Your ref: SSD 17352813
File no: MC-21-00001

**SSD 17352813– Huntingwood Processing Facility Expansion – 65
Huntingwood Drive, Huntingwood**

Blacktown Council's submission to SSD 17352813 – Huntingwood Processing Facility Expansion

1. Drainage Engineering Issues

CIVIL DESIGN  
 CONCEPT STORMWATER WSUD  
 CATCHMENT PLAN

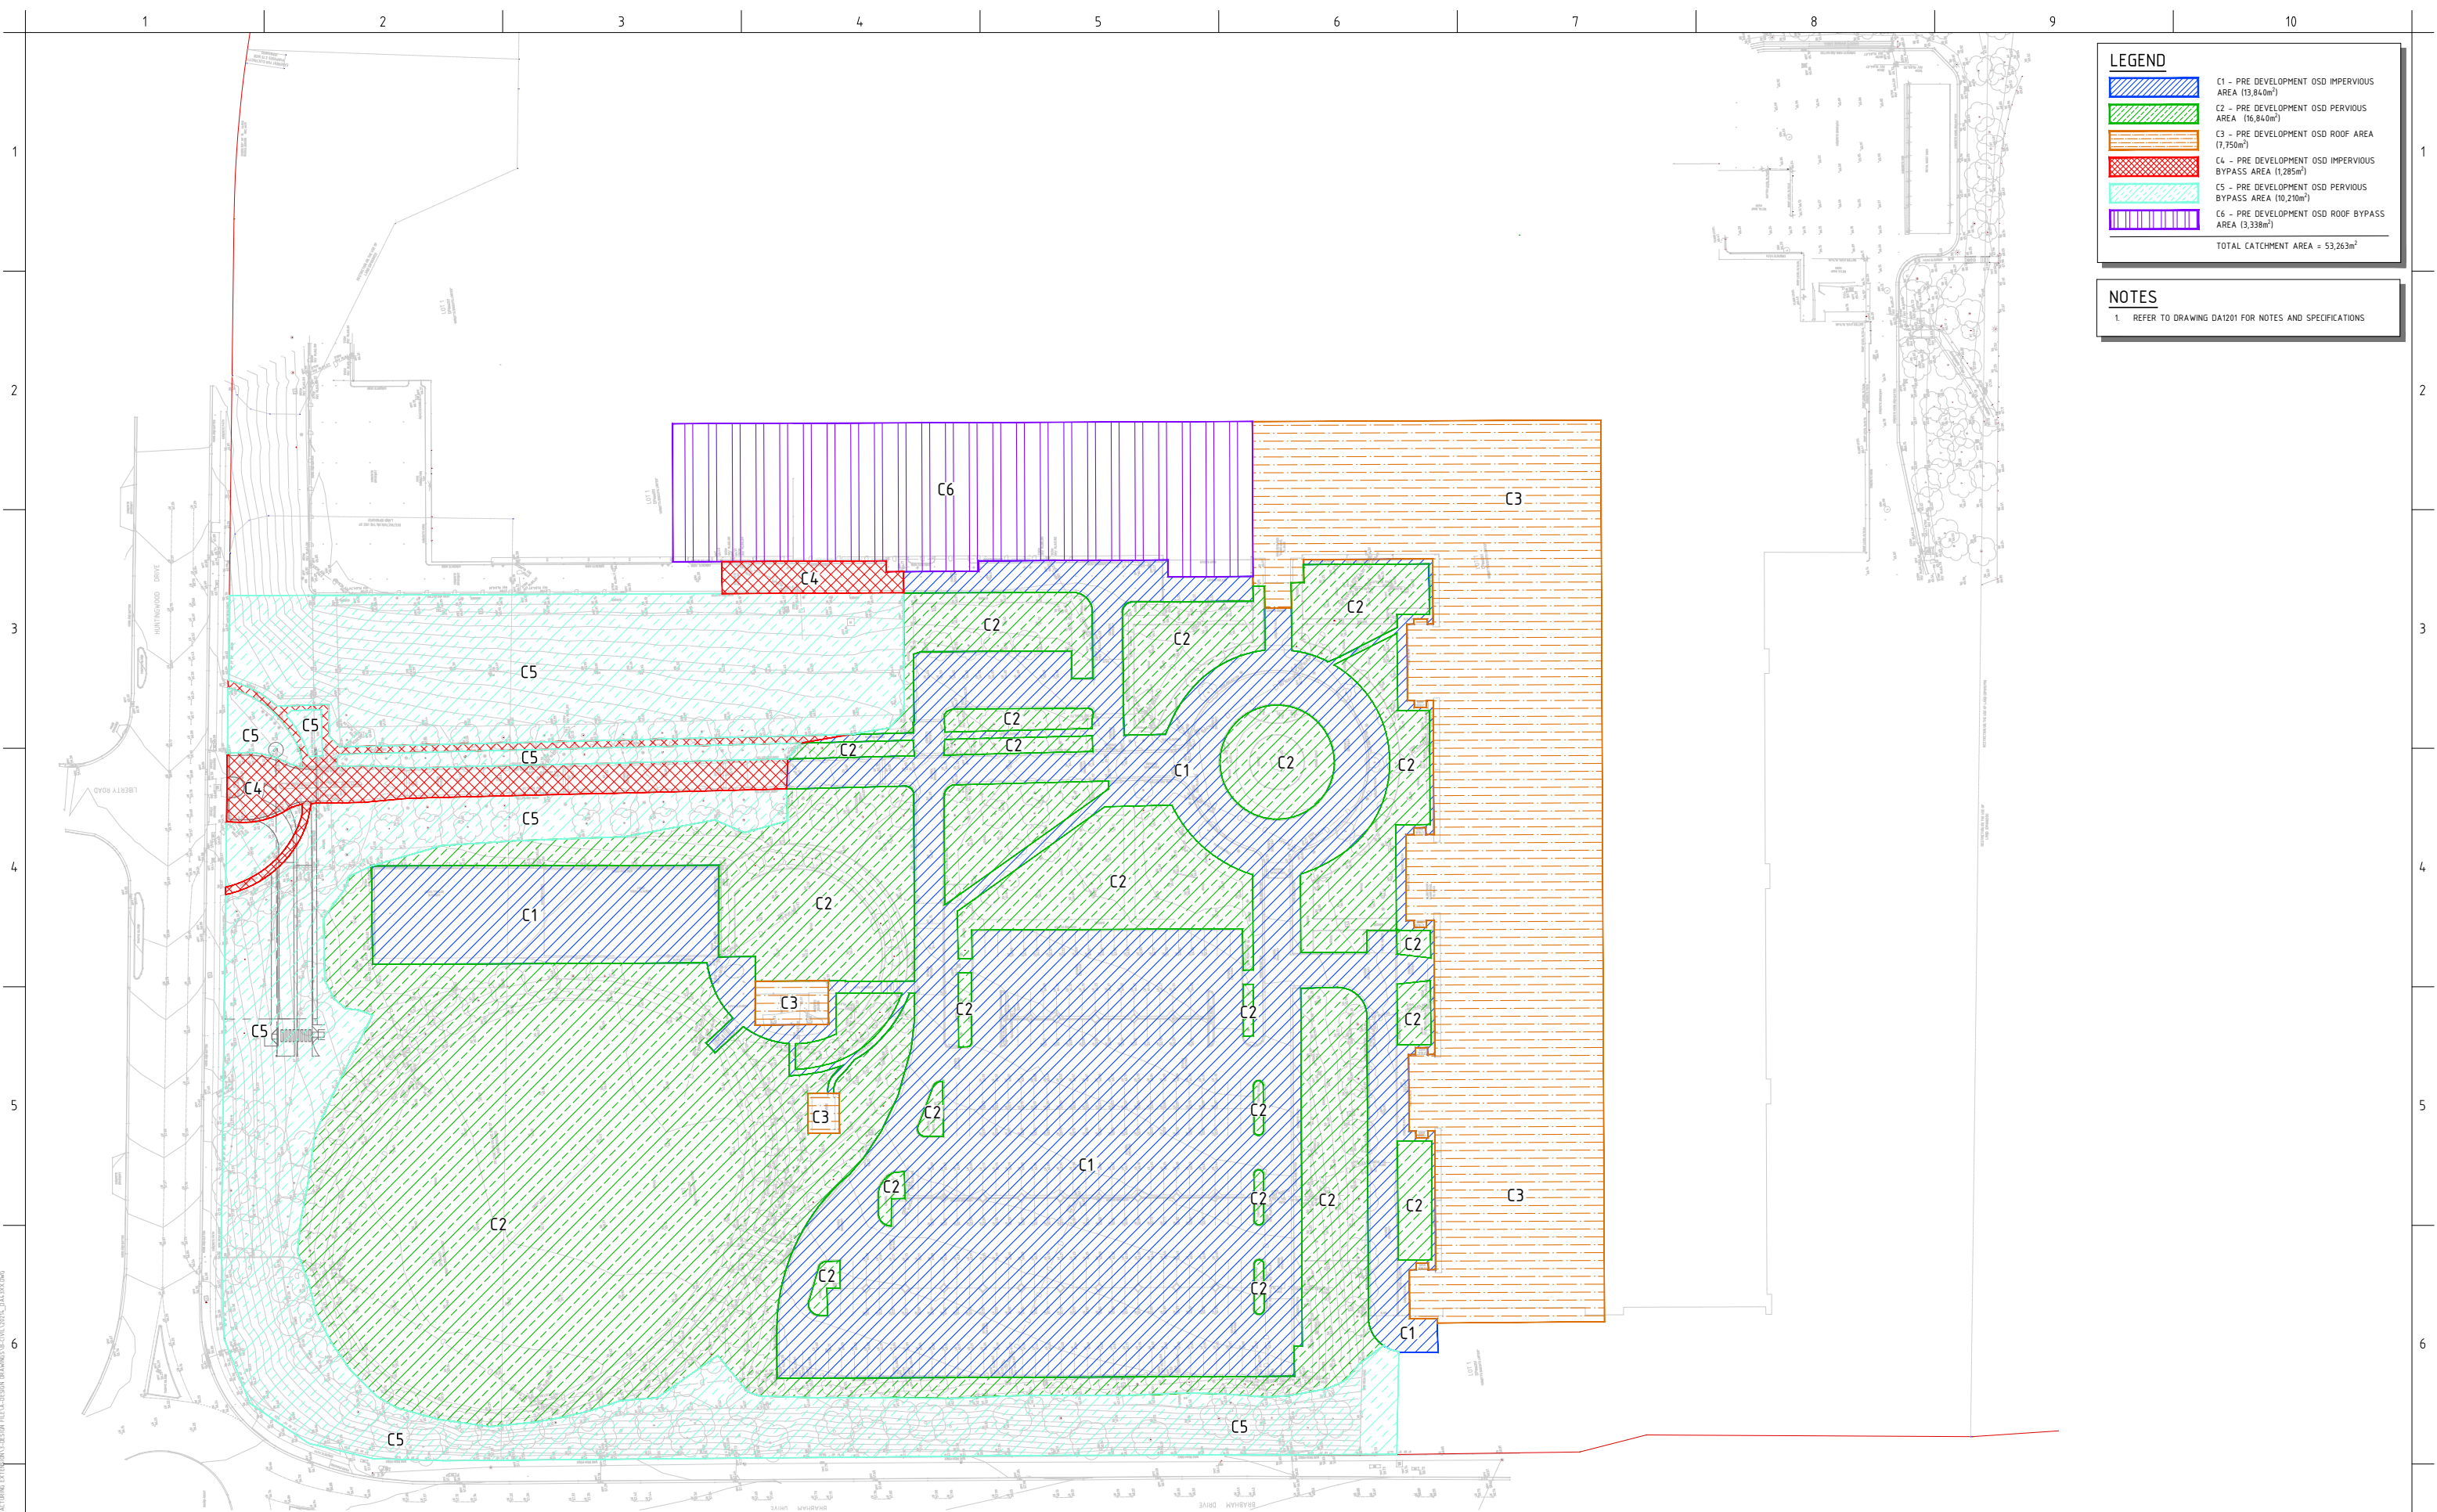
- b. It appears that on Dwg. DA4301 ancillary catchment (1790 + 313m²) are unaccounted for. These are to be either treated or considered as bypass for Water Quality. Confirm water quality approach regarding the ancillary catchment (1790 + 313m²) as shown on Dwg. DA4301.

- d. Ensure Model for Urban Stormwater Improvement Conceptualisation model matches the plans in terms of names, abbreviations, areas and land use.
- e. Label each sub-catchment on Dwg. DA4301 i.e. on top of the hatchings for ease of identification.

- h. All pits with OceanGuards are to be clearly noted on the plan.

**FIRST FLUSH/SIPHONIC BREAK PIT DETAIL**  
SCALE 1:25

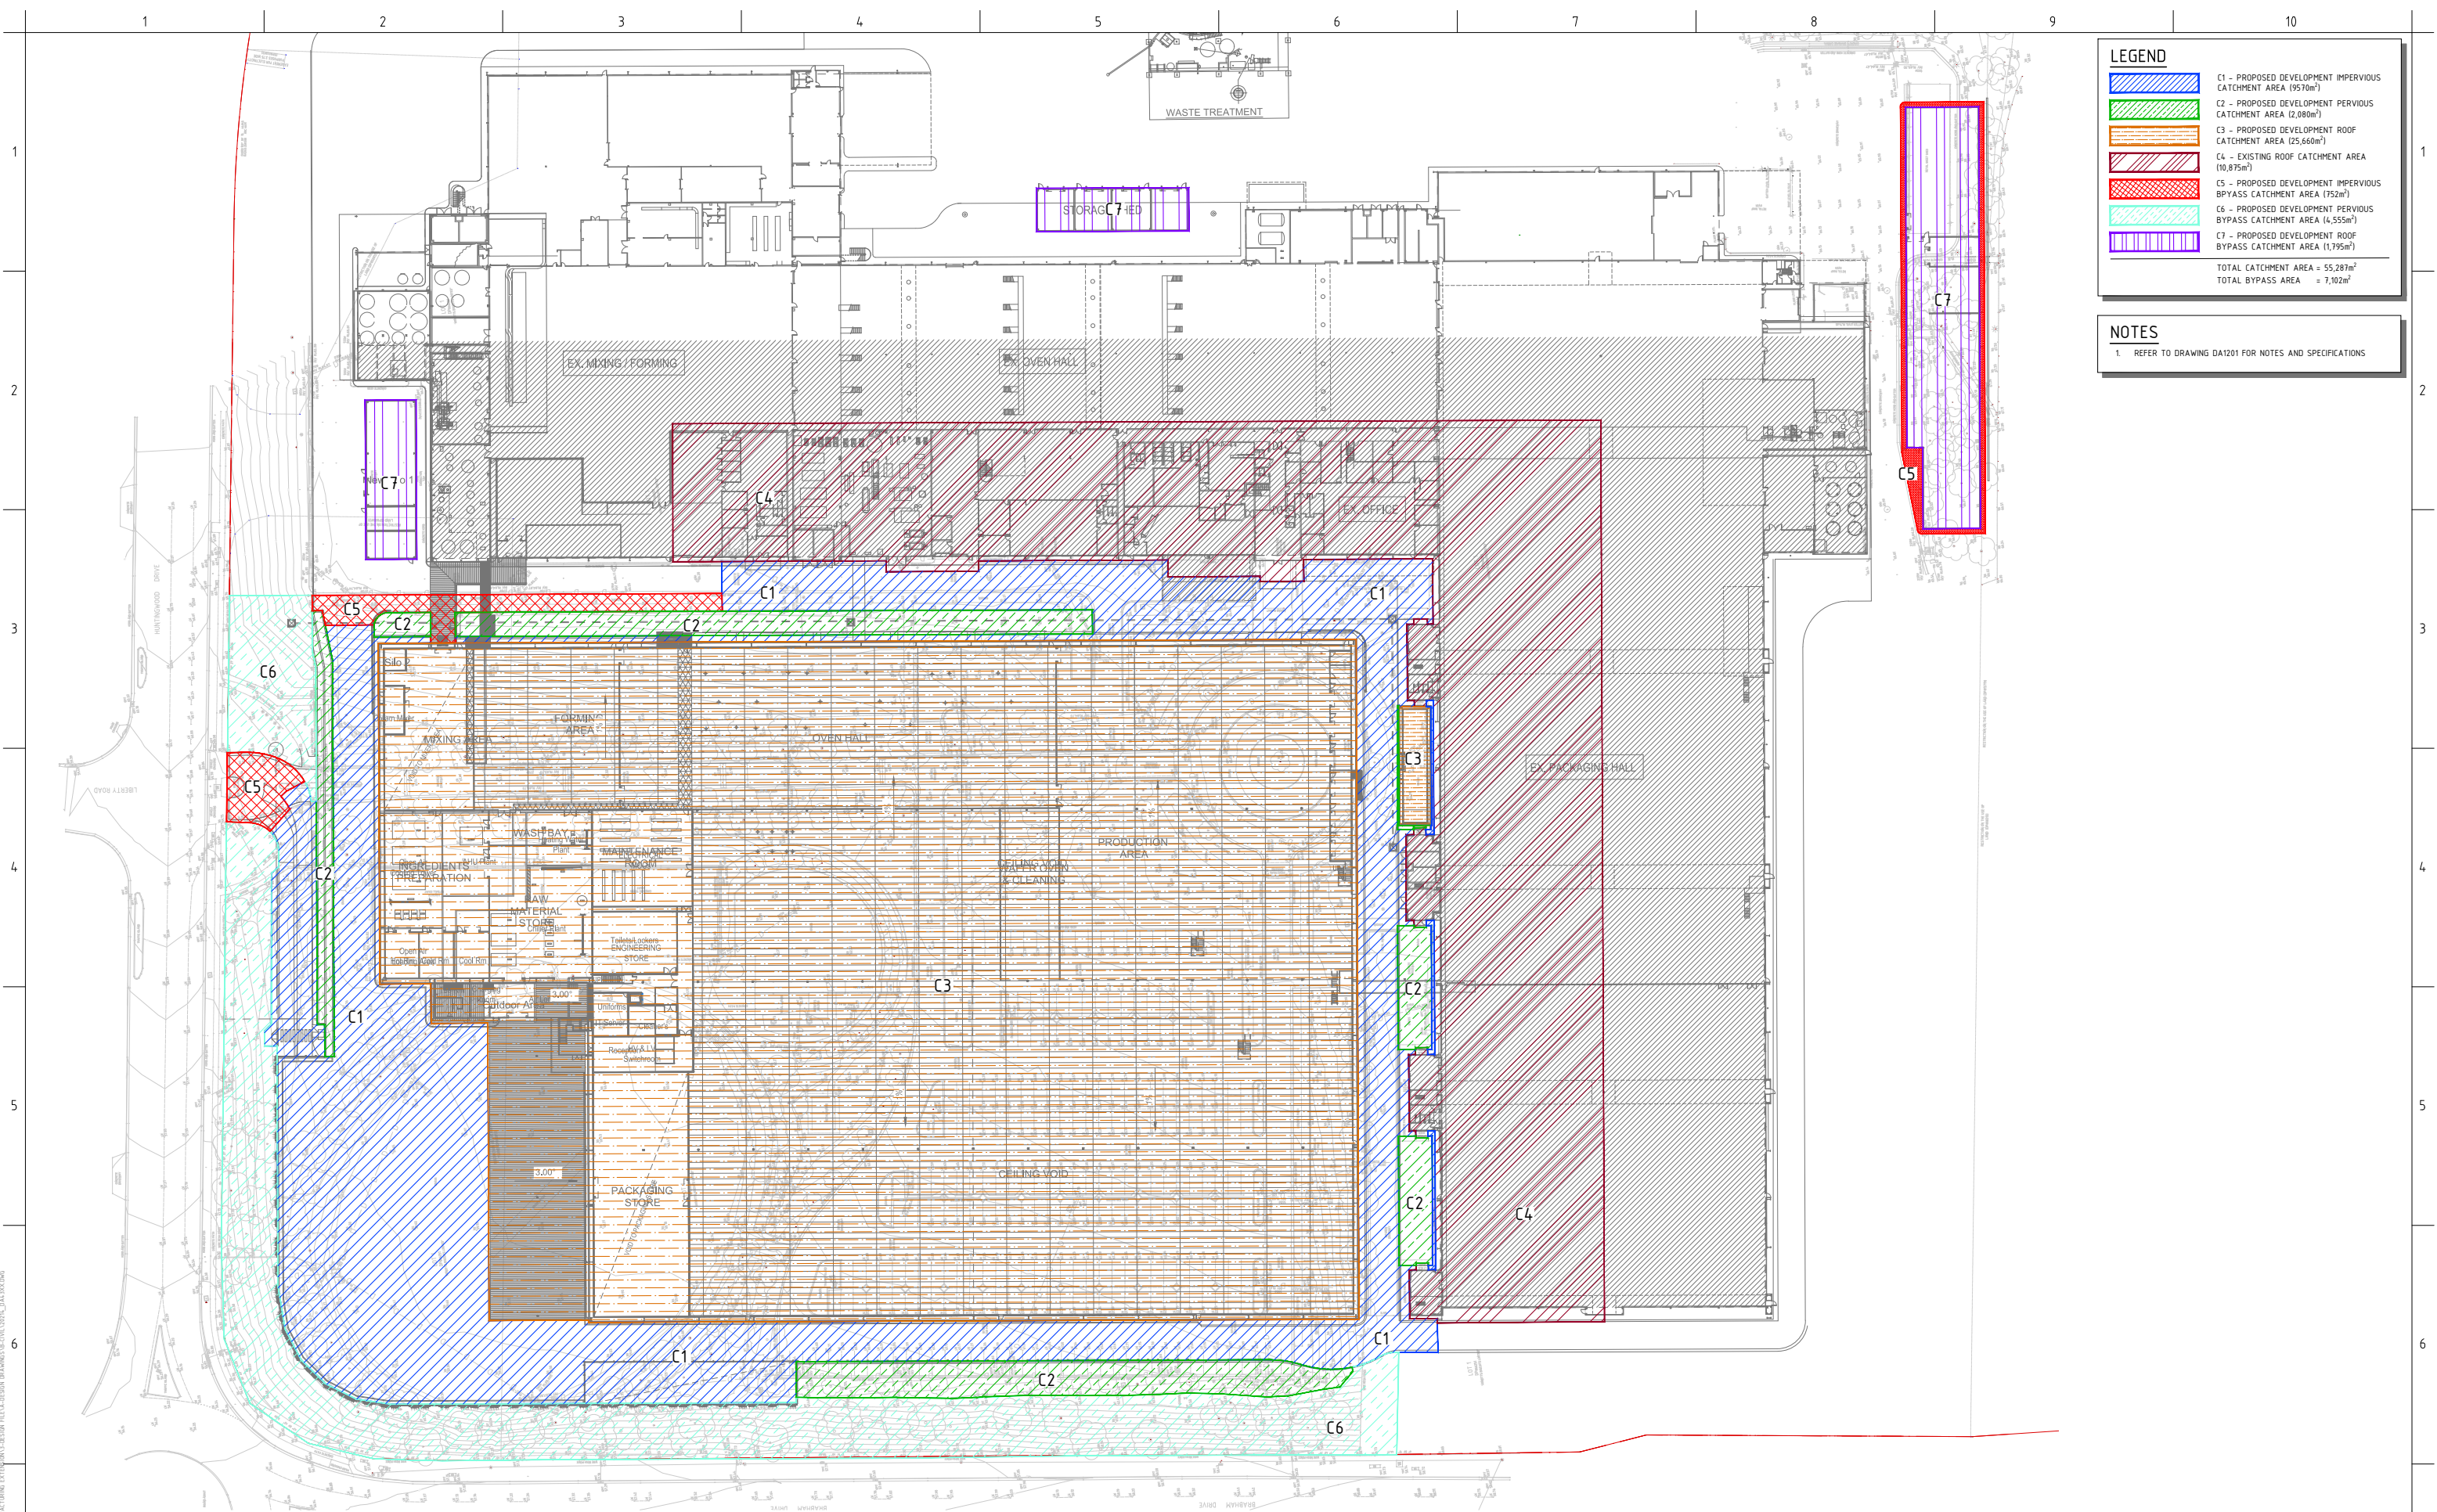
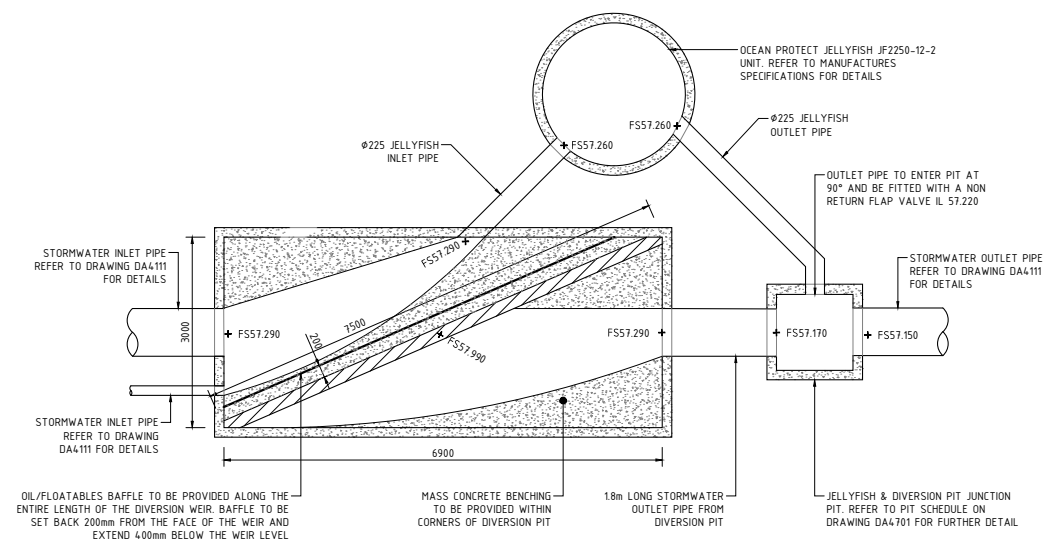
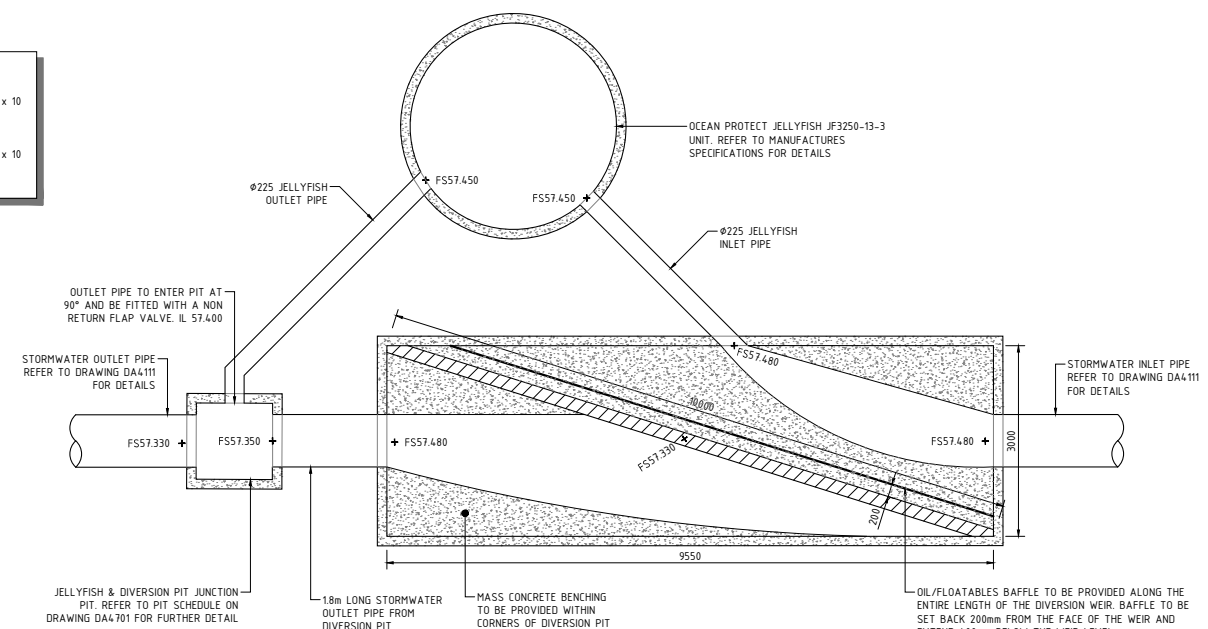
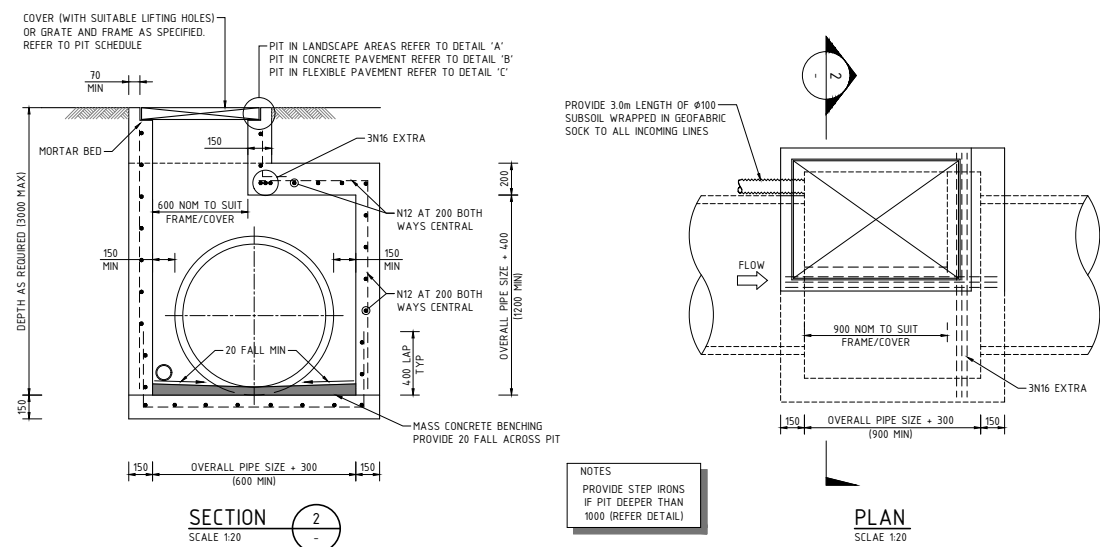
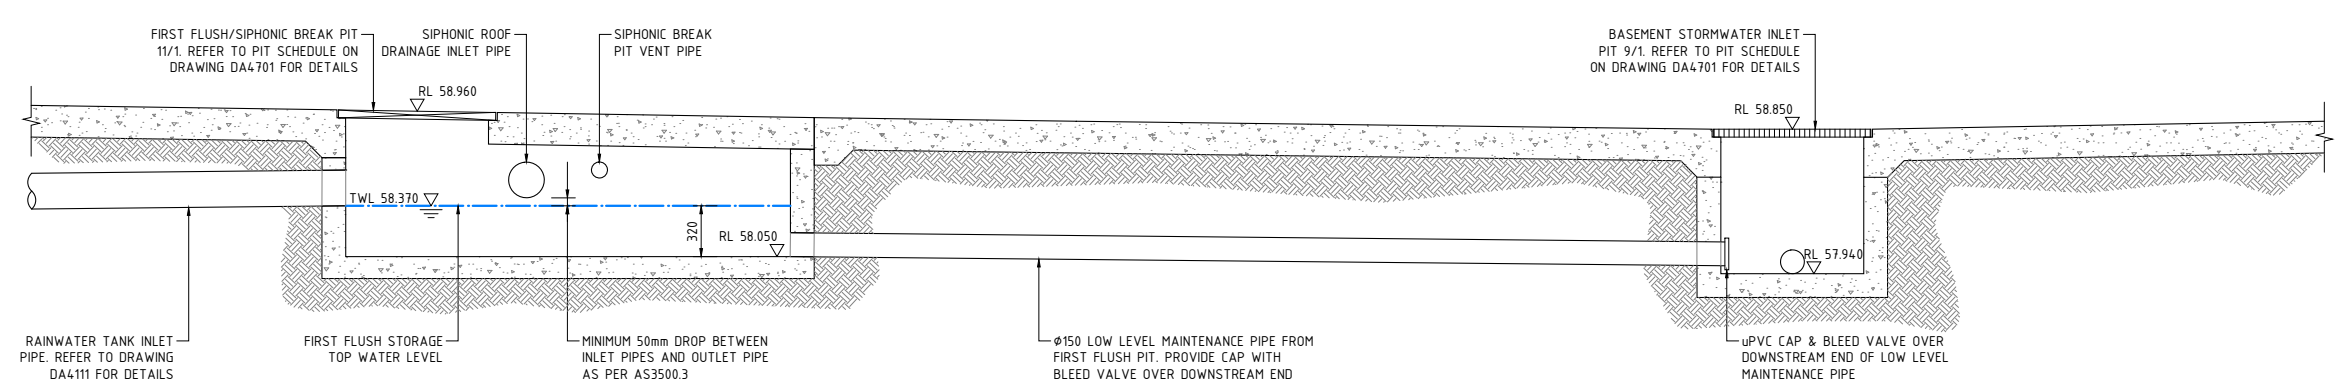
- f. Provide details of the first flush pit (this is to be sealed)
- g. Uncovered (no roof above) On-Site Detention area is to be considered bypass for water quality.

- f. Provide information on the total catchment area for 'SF1, SF2, bypass for water quality.
- g. Jellyfish calculations, detailed drawings, levels and splitter pits are to be provided to as per the Water sensitive urban design developer handbook chapter 12.13.
